REQUEST	Current Zoning: MUDD-O, mixed use development district-optional Proposed Zoning: MUDD-O SPA, mixed use development district-optional, site plan amendment
LOCATION	Approximately 3.60 acres located on the east side of South Tryon Street between East Palmer Street and East Catherine Street.
CENTER, CORRIDOR OR WEDGE	Corridor
SUMMARY OF PETITION	This petition proposes a site plan amendment to allow existing columns for a pedestrian bridge, which were not included in the original rezoning plan, to remain in the setback. The conditions and uses permitted under the previous rezoning are retained.
STAFF RECOMMENDATION	Staff recommends approval of this petition upon resolution of outstanding issues. The petition is consistent with the <i>South End Transit Station Area Plan</i> .
Property Owner	Summit Properties Partnership and Camden Property Trust
Petitioner	Steve Smoak
Agent/Representative	Susan Cannon and Walter Fields

PLANNING STAFF REVIEW

PEDESTRIAN BRIDGE ENLARGEMENT - 1" = 10'

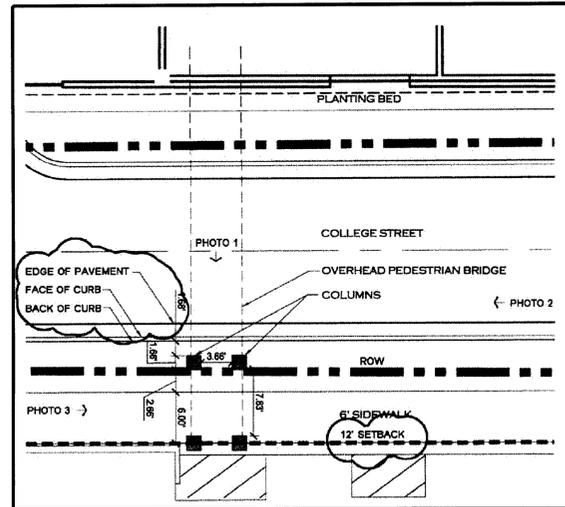
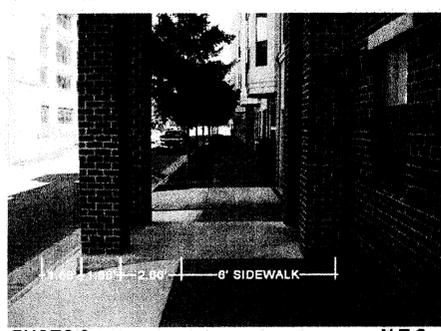
1. Specify that the optional request is to allow two existing columns for a pedestrian bridge to remain in the setback and right-of-way on the southern side of South College Street.
-
